**WELWYN HATFIELD BOROUGH COUNCIL
EXECUTIVE DIRECTOR - PLANNING, PUBLIC PROTECTION AND GOVERNANCE**

DELEGATED APPLICATION

Application No: 6/2022/2168/FULL
Location: 87 De Havilland Close Hatfield Hertfordshire AL10 0DP
Proposal: Provision of kitchen facility to facilitate the creation of a separate dwelling from existing HMO property
Officer: Ms Kirsty Shirley

Recommendation: Refused

SCALE 1:100 @A3 UNLESS OTHERWISE STATED DATE SEPT 2022
DRAWING No. DHC 102-1 REV. A

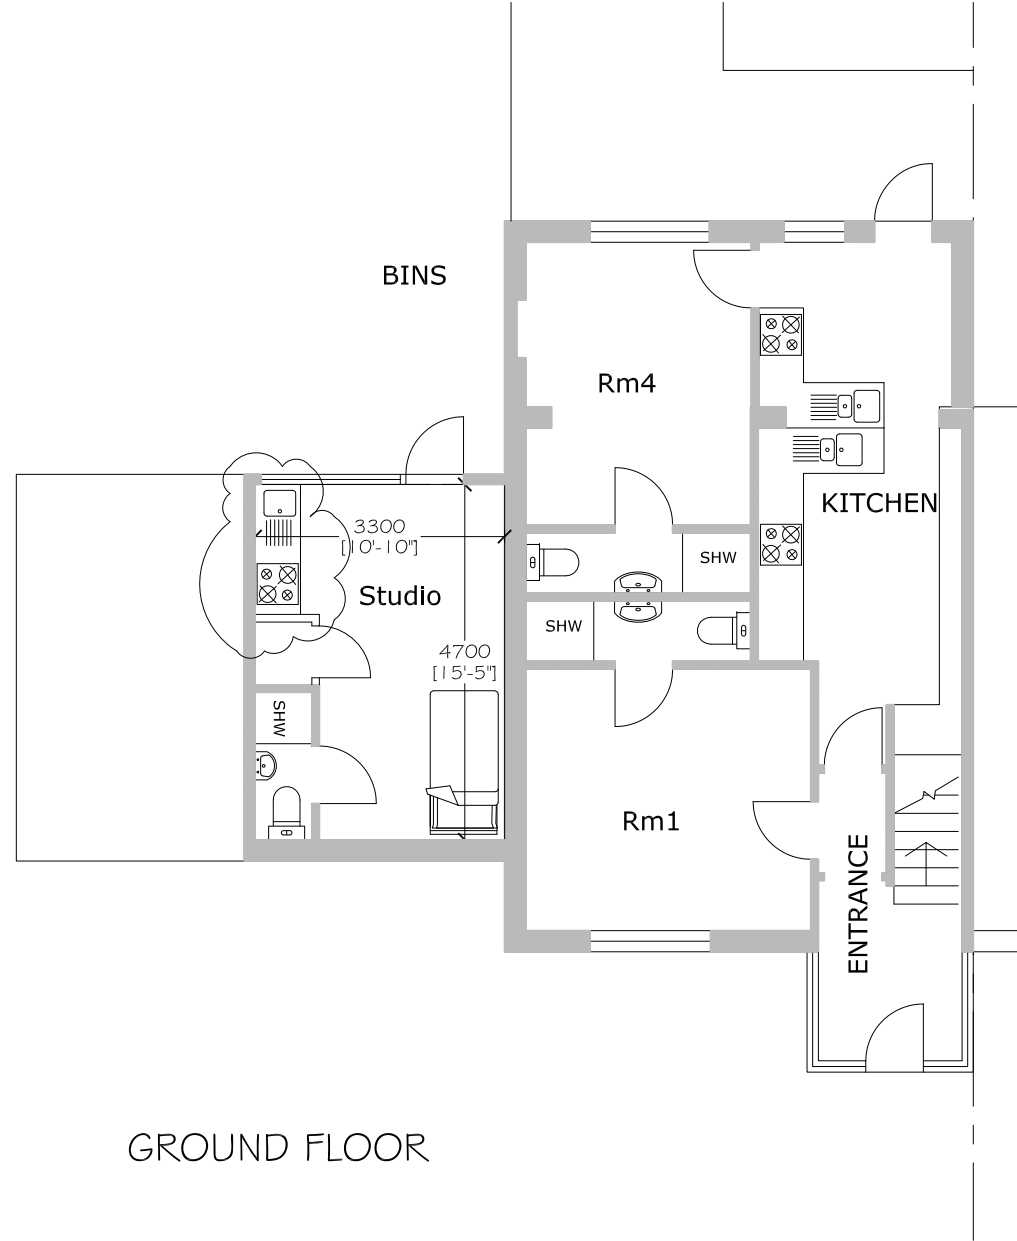
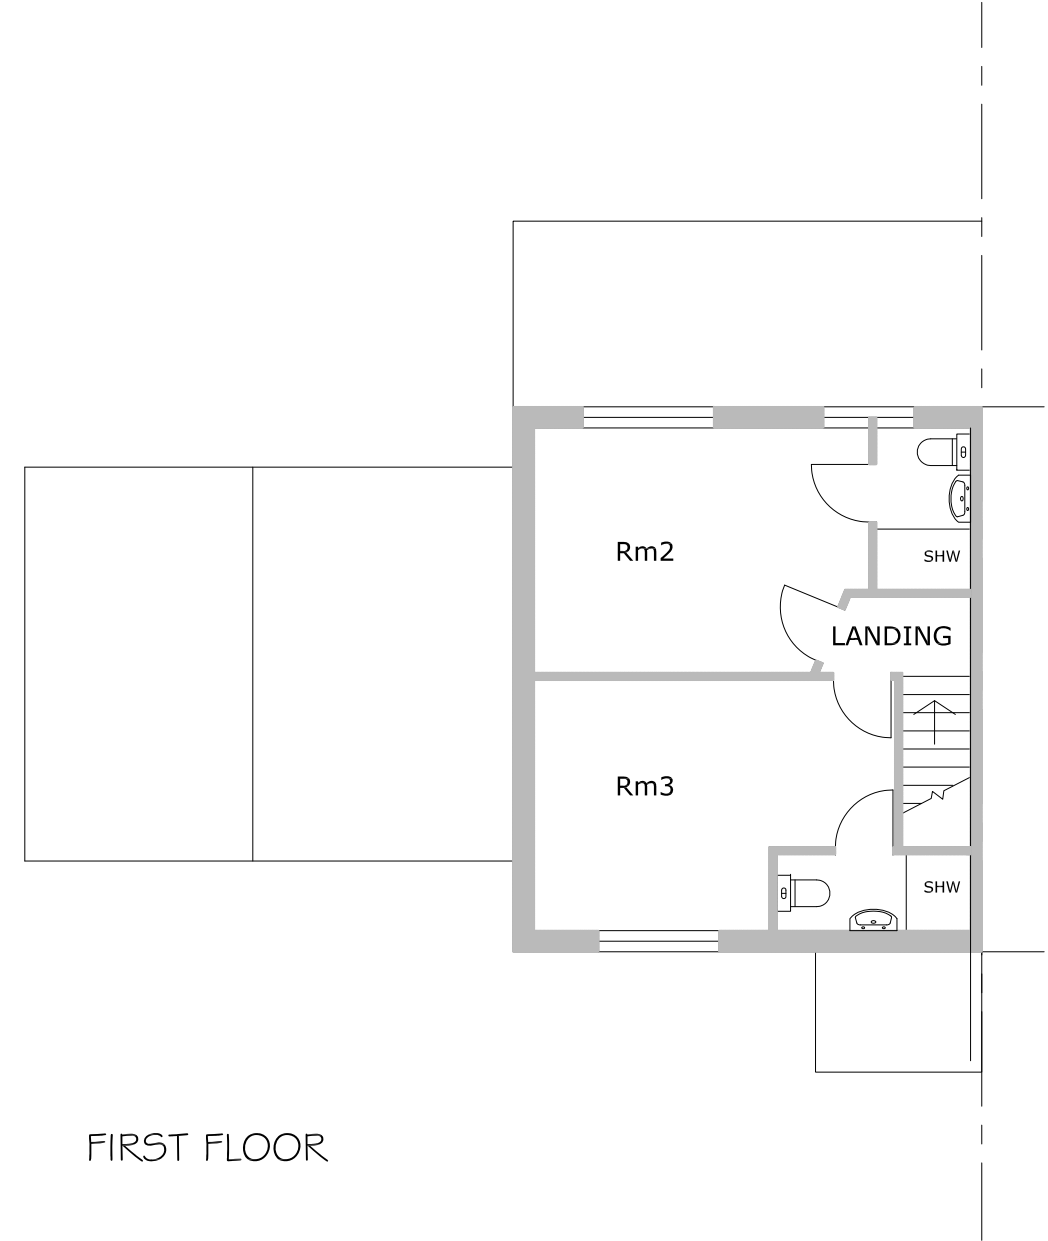
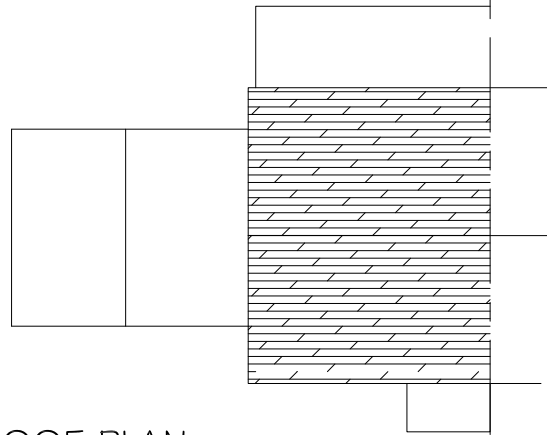
<p>Future occupiers of the of the self-contained unit would not have access to on-site outdoor recreation. This would prevent the occupiers of the dwelling from experiencing appropriate living conditions. In particular, this arrangement would diminish the ability of future residents from undertaking outdoors recreation, including play. In addition, the lack of garden space would also reduce opportunities for future occupiers from matters such as the storing of household waste or undertaking domestic tasks such as the drying of washing.</p> <p>The development would be positioned in close proximity to amenity area to the rear of the site. The amenity area is encircled by dwellings with established trees running throughout. Whilst the amenity area could be used for some recreation, it would not be of a suitable size to undertake a variety of activities. In addition, the amenity area would not have the same level of privacy or functionality as a garden. In consequence, the presence of this space does not outweigh the lack of private on-site outside amenity space.</p> <p>The development would therefore be in conflict with District Plan Polices D1 and H4; the Supplementary Design Guidance; and the National Planning Policy Framework.</p>

<p>Impact on neighbours</p>	<p>Two objections have been received for this development. The objections regard the size of the unit, bin storage, parking and antisocial behaviour.</p> <p>Concerns regarding the size of the unit, bin storage and parking have been addressed elsewhere.</p> <p>Matters regarding anti-social behaviour are not material planning considerations but informatives can be included in the event of an approval to advise the applicant.</p> <p>The resulting increased density of the site is not considered to be substantial and the potential for additional noise or disturbance as a result would not be sufficient to justify a refusal on this basis alone. In this respect, no objections are raised with regard to Policy H4, D1 and R19.</p> <p>The development would not result in an alteration to the size, scale, positioning or fenestration of the site. The development would therefore not result in adjoining neighbours to experience a detrimental loss of privacy or sunlight, nor would the development appear overbearing or unduly dominant towards adjoining occupiers.</p>

<p>The application site is within Zone 3 where bedsits/1 bedroom dwellings should provide 1.25 car parking spaces. The plans submitted with this application do not show any car parking arrangements.</p> <p>The closest roads to the application site would be Worcester Road to the east of the site and De Havilland Close to the south of the site. These areas have had issues with car parking as evidenced by a permit holder scheme in both Worcester Road and De Havilland Close. An under provision of on-site car parking is therefore not acceptable in this location.</p> <p>The proposal would result in an unacceptable under provision of on-site car parking spaces. The proposal therefore fails to comply with Policies D1 and M14 of the Welwyn Hatfield District Plan; the Supplementary Design Guidance; the Supplementary Planning Guidance on Parking Standards; and the National Planning Policy Framework.</p>

1. The proposed creation of a self-contained unit, by virtue of size of the unit and absence of external private amenity space, would represent development that would result in unsatisfactory living accommodation for the future occupants. Accordingly, the development would be of a poor standard of design, failing to take the opportunities to function well and add to the overall quality of the area, contrary to Policies D1 and H4 of the District Plan; Policies SP9 and SADM11 of the draft Local Plan; the Supplementary Design Guidance; and the National Planning Policy Framework.

2. The proposed development does not include suitable bin storage, resulting in harm to the character and appearance of the area. The development therefore represents a poor standard of design which conflicts with Policies D1 and D2 of the Welwyn Hatfield District Plan; Policies SADM11 and SP9 of the draft Local Plan; the Supplementary Design Guidance; and the National Planning Policy Framework.

3. The proposed development would result in an unacceptable under provision of on-site car parking spaces, and consequently fails to comply with Policies D1 and M14 of the Welwyn Hatfield District Plan; the Supplementary Design Guidance; the Supplementary Planning Guidance on Parking Standards; Policy SADM3 & SADM12 of the draft Local Plan Proposed Submission August 2016; and the National Planning Policy Framework.

4. The proposed development does not include any cycle storage, contrary to Policies 1, 5 and 8 of Hertfordshire's Local Transport Plan (adopted 2018); Policies M6 & M14 of the Welwyn Hatfield District Plan 2005; the Supplementary Planning Guidance on Parking Standards; Policy SADM3 & SADM12 of the draft Local Plan Proposed Submission August 2016; and the National Planning Policy Framework.
